**App no: 21.0525**

**Address: Discharge of Conditions of planning application 3/2014/0183. Condition 10 (Floor, ridge and eaves heights), 29 (Archaeology), 30 (Landscaping), 32 (Refuse), 35 (Site Access), 39 (Construction Management Plan), 41 and 43 (Foul and Surface Water Drainage), 44 (Site Investigation), 47 (Bird Nesting), 48 (Nesting Bird Check), 49 (Trees and Bats), 50 (Otters), 51 (Invasive Species), 52 (GCN Check), 53 (Badgers), 54 (Water Vole), 55 (Landscape Plan), 56 (Landscape Management), 57 (TPO Details)**

**Proposal: Land at Malt Kiln Brow**

Rev	Revision History	By	Date
Client: SCPI (Bowland) Ltd			
Site: Land off Malt Kiln Brow, Chipping (P4)			
Drawing: Traffic Management Plan			
Drawing Number: CRC-TMP-01			
Scale: 1 : 500	Size: A2	Date: 05/05/2021	
Drawn: SJS	Checked:	Rev:	
Status: Construction

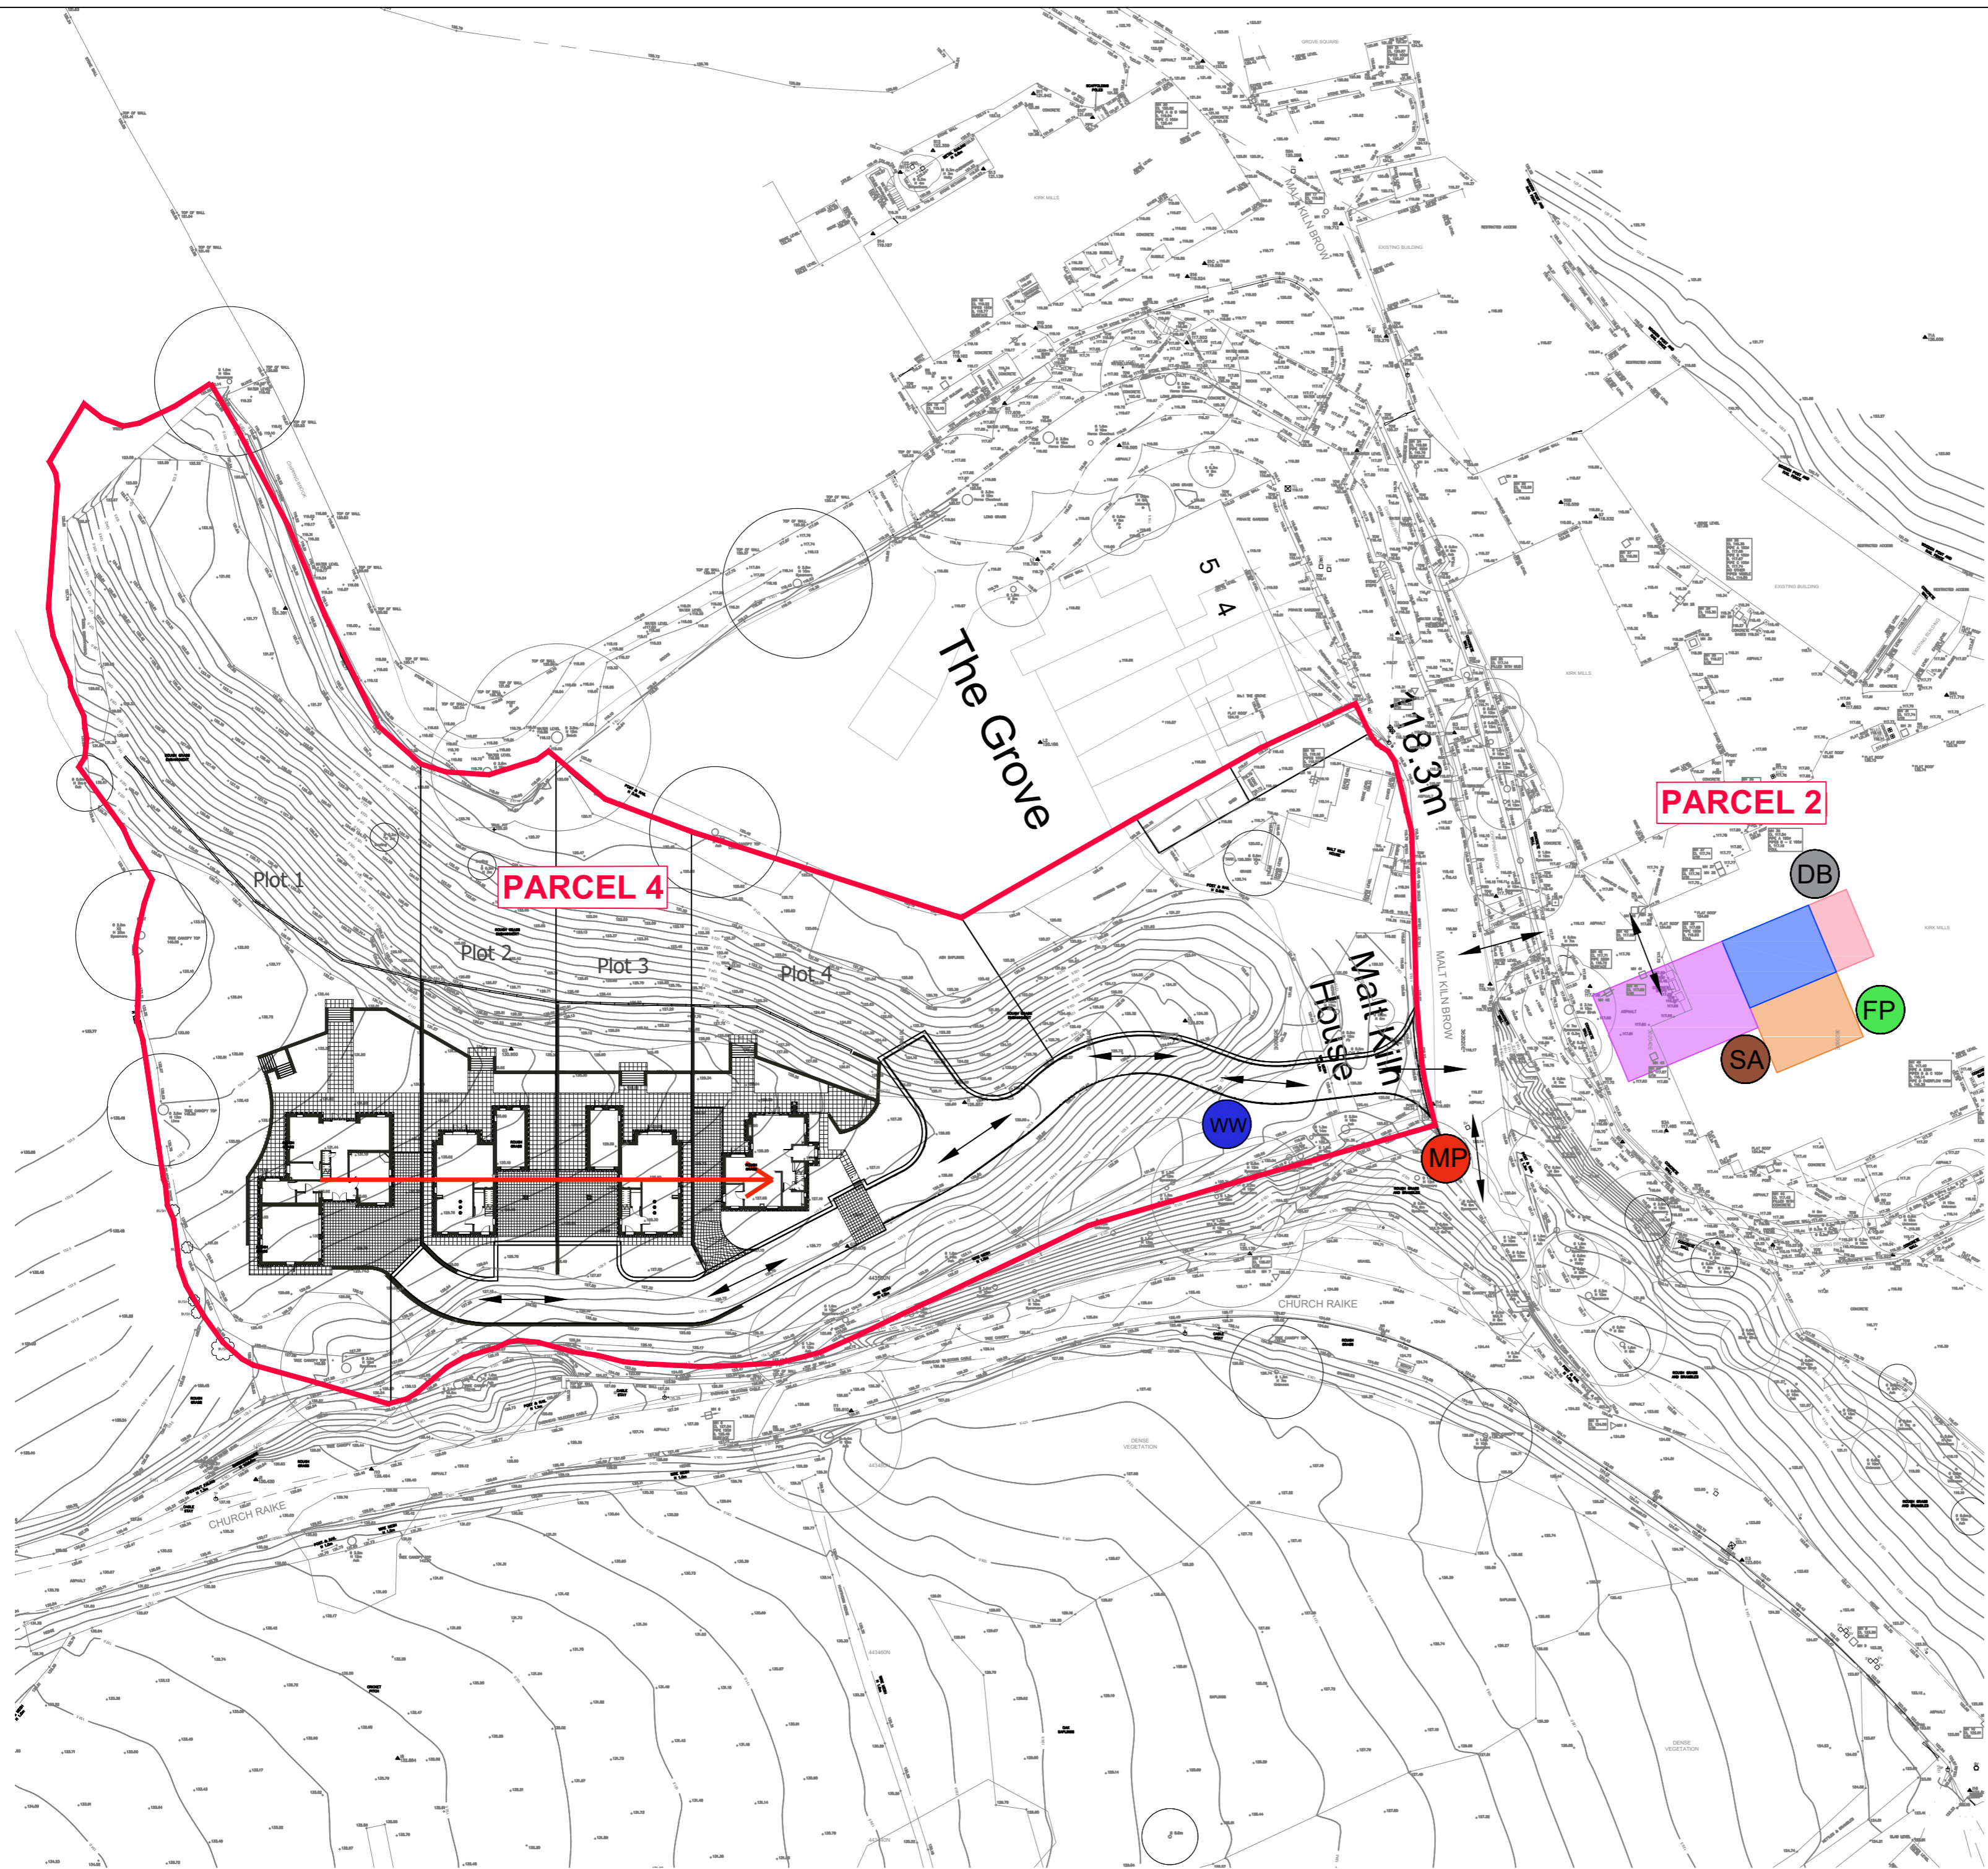
There are concerns about the location of the material store within parcel 2 which results in materials being moved between sites along sections of adopted highway which have limited visibility and no separate footways. This has resulted in safety issues being reported to Lancashire County Council by highway users on Malt Kiln Brow and Church Raike. The parking of operative's vehicles on Fish House Lane and Malt Kiln Brow is restricting the movement of large vehicles and reducing areas for pedestrians to use as refuge whilst large vehicles pass by.

The off-loading of materials from large vehicles on Church Raike has been reported which poses a safety concern.

There are a number of safety issues arising from the existing construction operation therefore we would request that the existing arrangements are reviewed and re-submitted before this condition is discharged.
